From: [Cary Henderson](#)
To: [Jeff Watson](#)
Subject: Plain Beautiful Short Plat (SP-10-00012)
Date: Wednesday, October 20, 2010 2:23:33 PM

We are adjacent property owner's to the subject proposed short plat. We live at 91 Galaxy Drive in Ellensburg and my property is Lot 17 of the High Valley Lakes Plat.

SHEET 1 OF 3

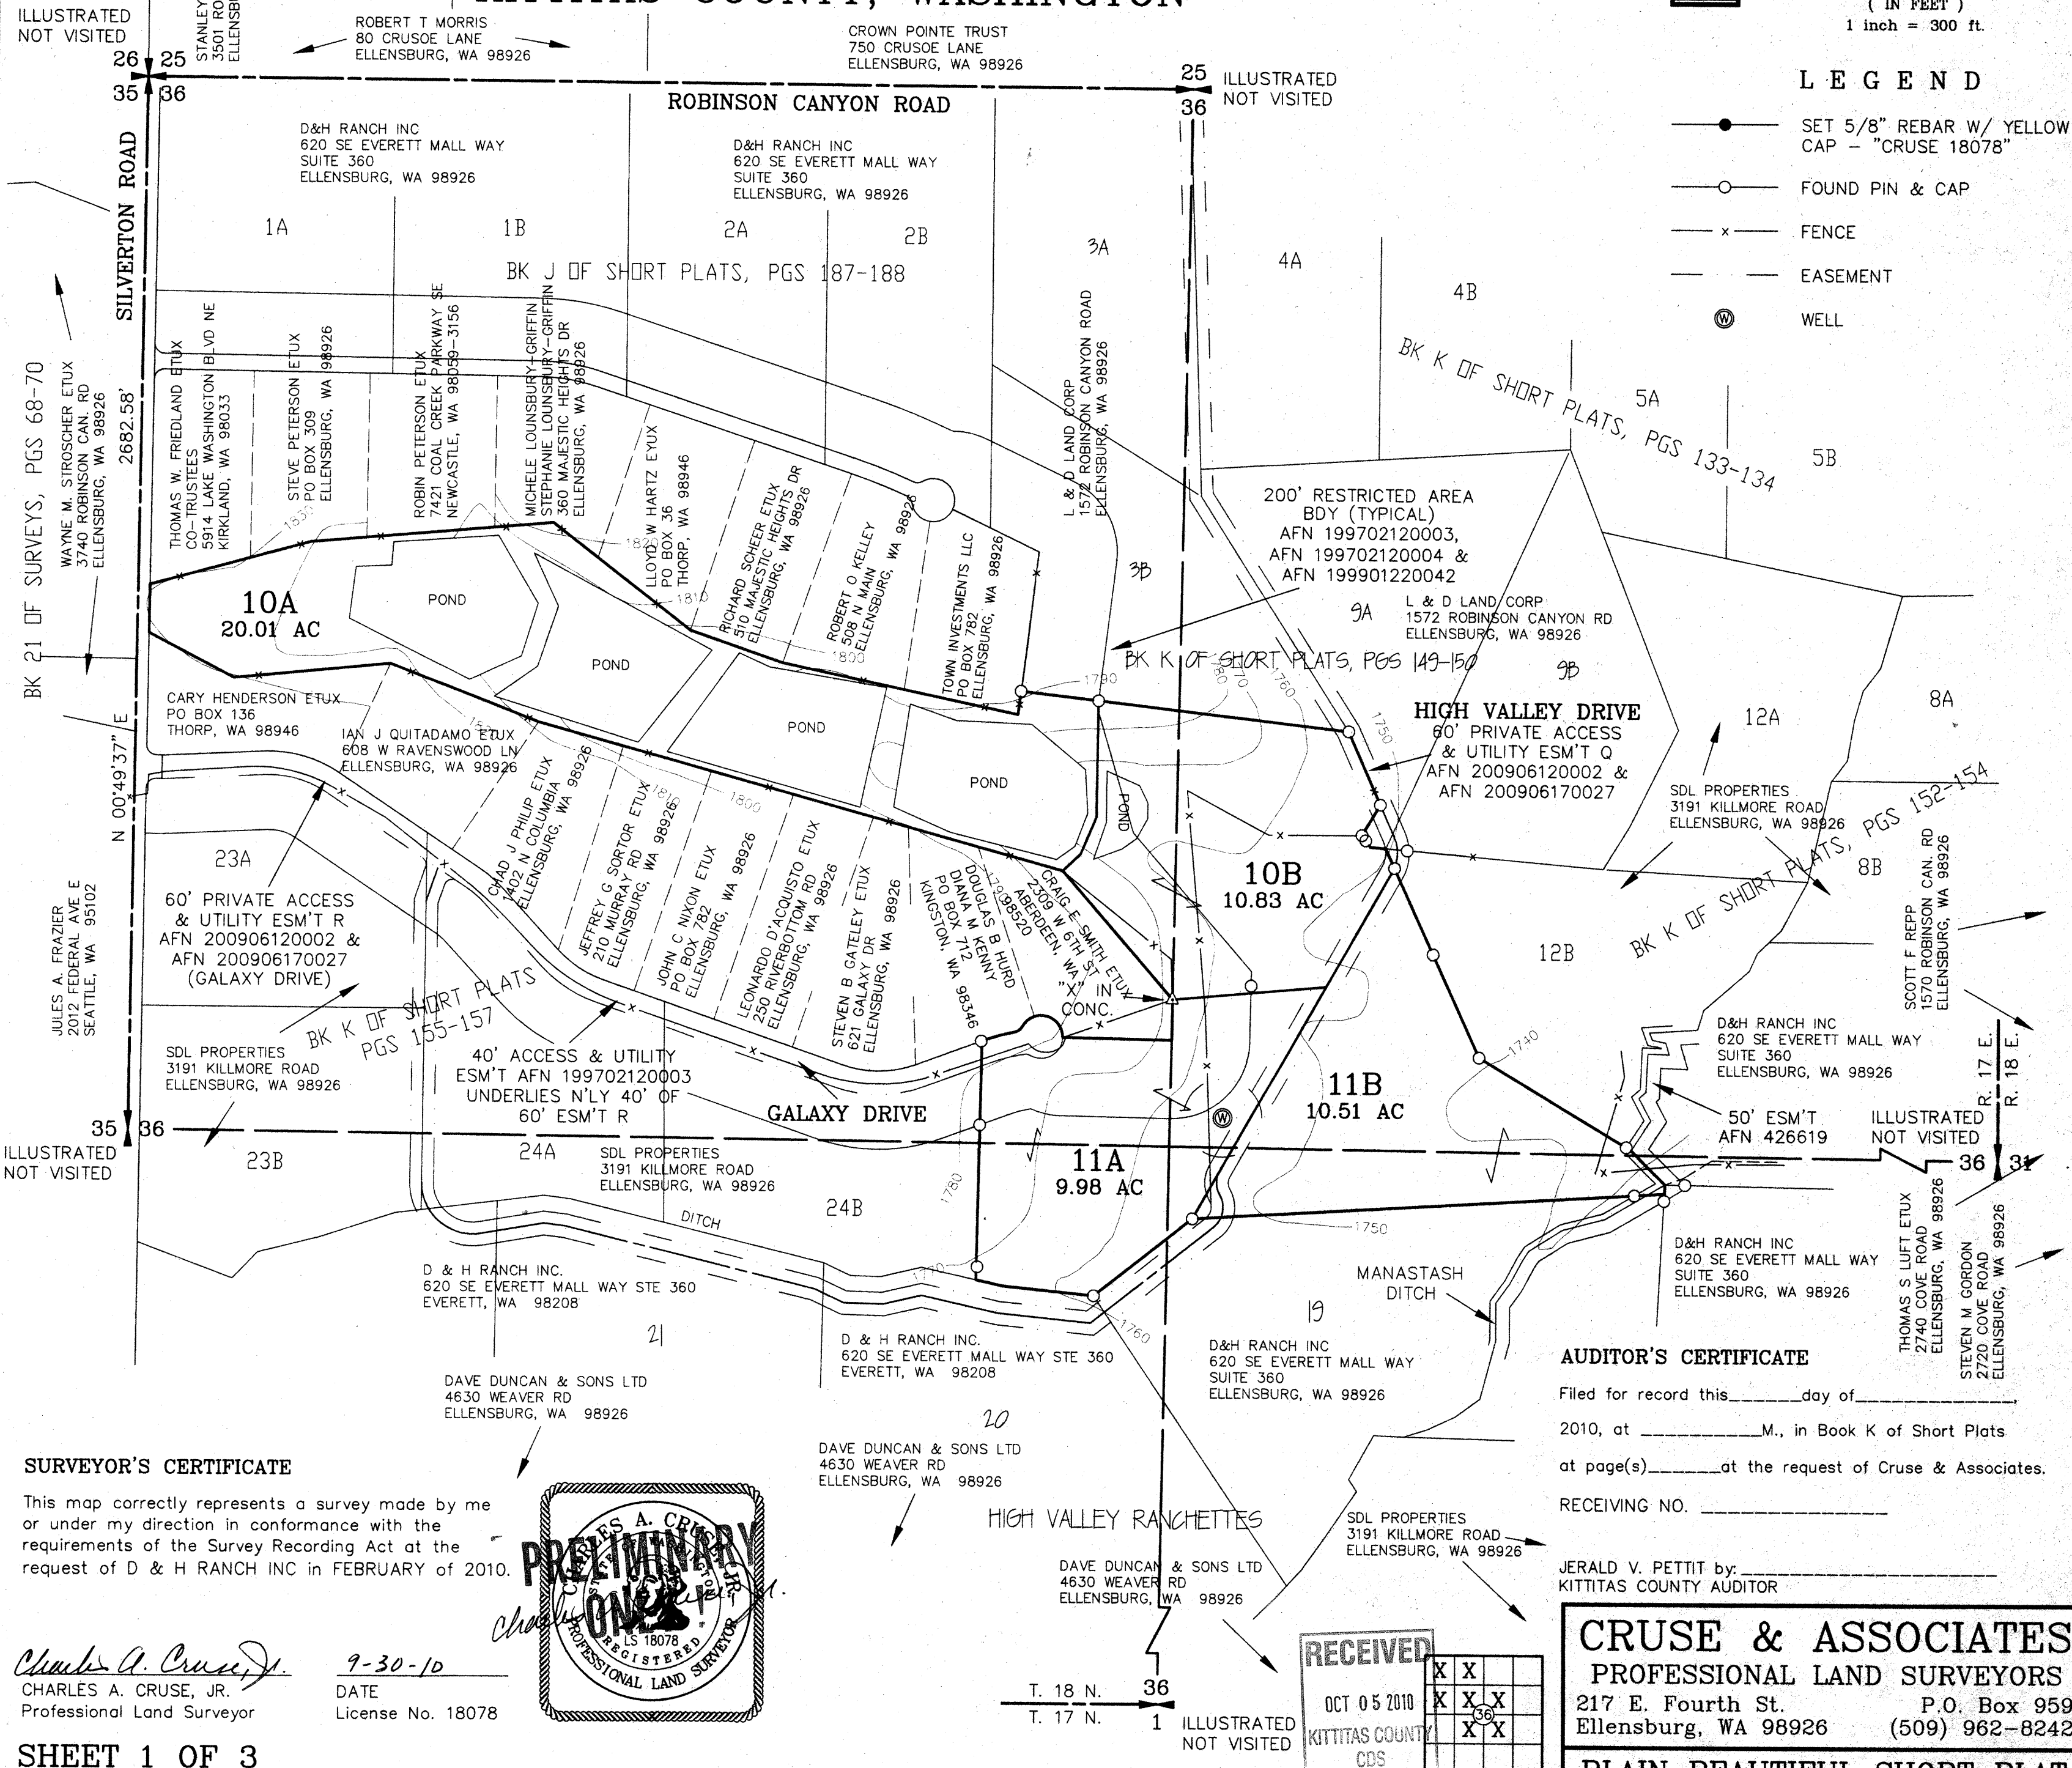
As I stated this afternoon, the covenants in para. 3.5 of (AFN 199901220042) shown on the face of the proposed plat, clearly state that "No building shall be constructed or vehicles stored on any portion of Lot 18 which is within 200 feet of any Lot or in the area of the survey between Lots 1 through 8 on the north and Lots 9 through 17 on the South." Lots 1 through 18 are according to short plat recorded February 12, 1997 under Kittitas Auditors file No. 199702120004.

We request that the above condition be placed on the face of this plat to insure the landowners of lots 1 through 17 have their rights reserved per para. 3.5 of AFN 199901220042.
